R/95/22/L

Herne Farm House 2 Park Drive Rustington BN16 3DZ

Listed building consent to replace 4 No ground floor windows on the front range of the original house and 3 No first floor windows in the modern extension to the rear and north of the original house

Windows to be Replaced
Figure 3.1

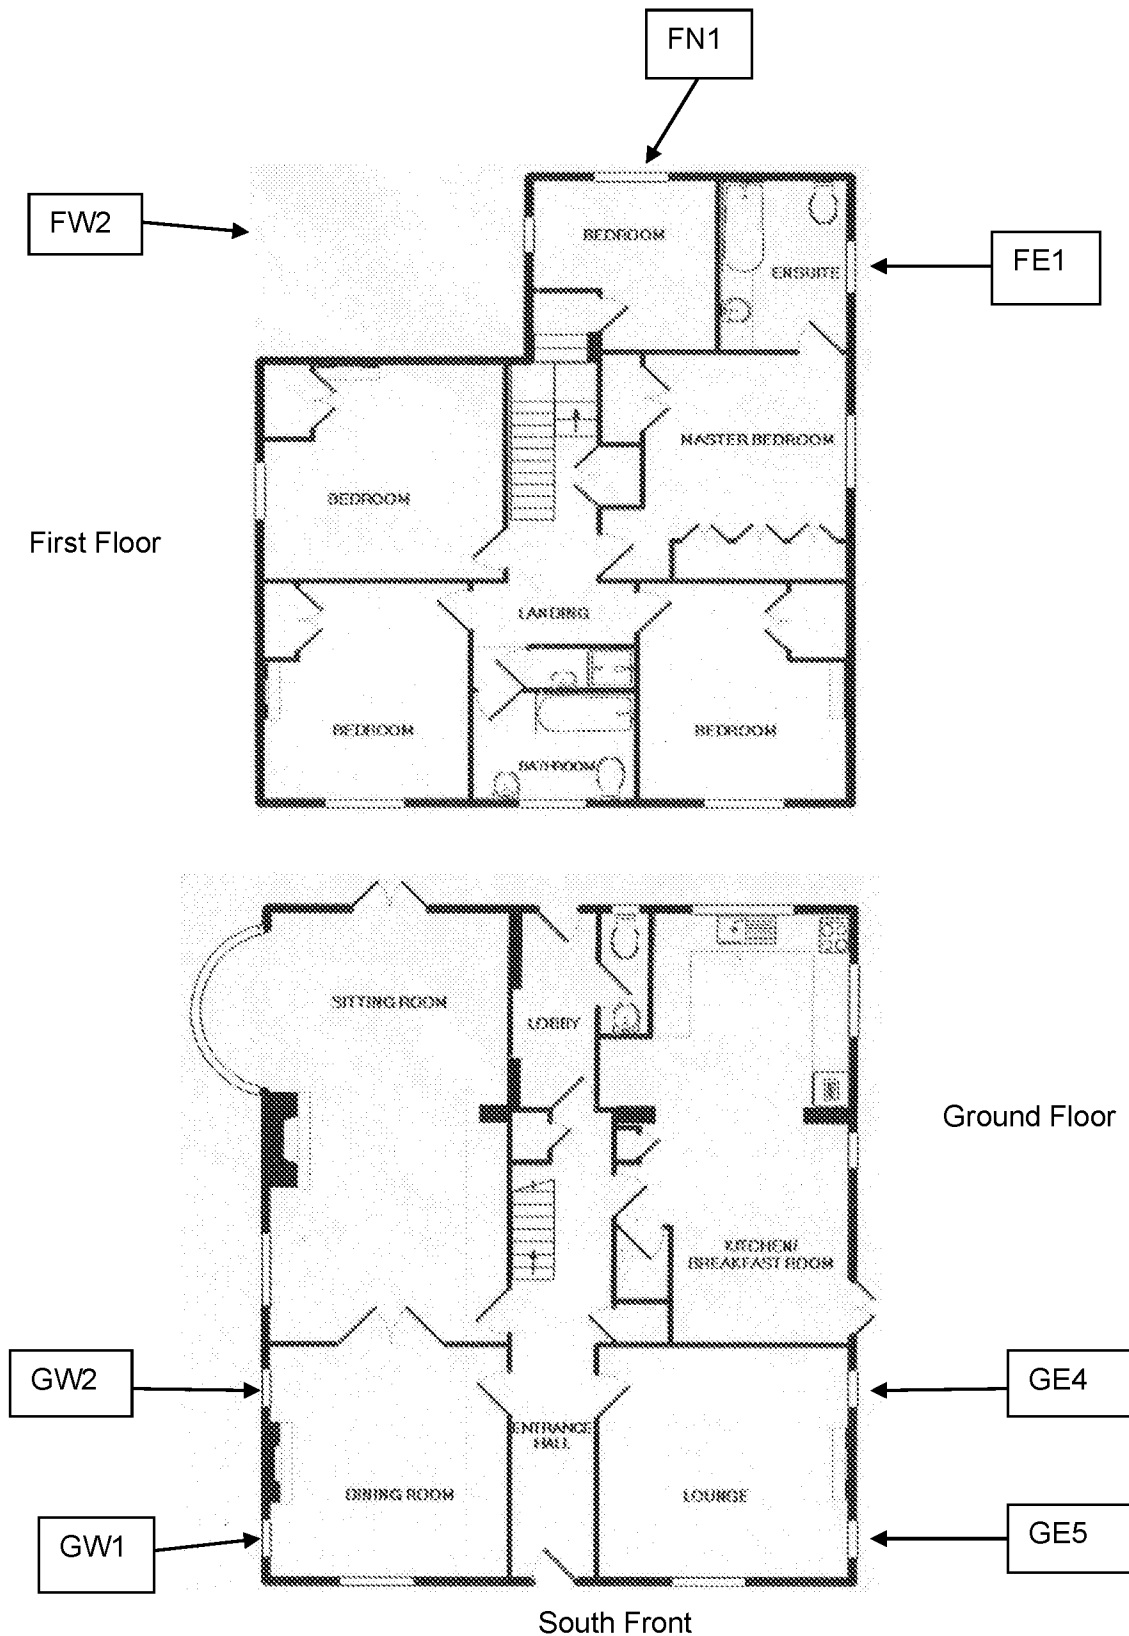
I note that the windows on the ground floor were not part of the original house but date from the early part of the twentieth century when two new openings were first formed. Further that their replacement is now necessary because it has now reached a point where renewal in some form has become a clear necessity. These windows will be replaced on a like-for-like basis with single glazing in order to respect the listed building. However, the replacement windows will be multi-paned to reflect the older windows in the listed building. Such an approach is positive.

The first floor windows to be replaced are located in a modern extension and are of modern manufacture with no historic fabric. I note that the intention is to replace these on a like-for-like basis, but with double glazing. This would have to be the slim profile double glazing, and this would have to be agreed as part of a condition.

Having reviewed the information, I am of the opinion that based on their age and appearance that they are of no significance and can be replaced. The only issue is to ensure that the replacement windows and doors are appropriate for the listed building.

Details of their design/appearance, specification, glazing bars, glazing, method of opening, location within the window opening and finish, in the form of drawings and sections of an appropriate scale, shall be submitted to and agreed in writing by the Local Planning Authority before the windows and doors are installed. The works shall be carried out only in accordance with the agreed window and door details.
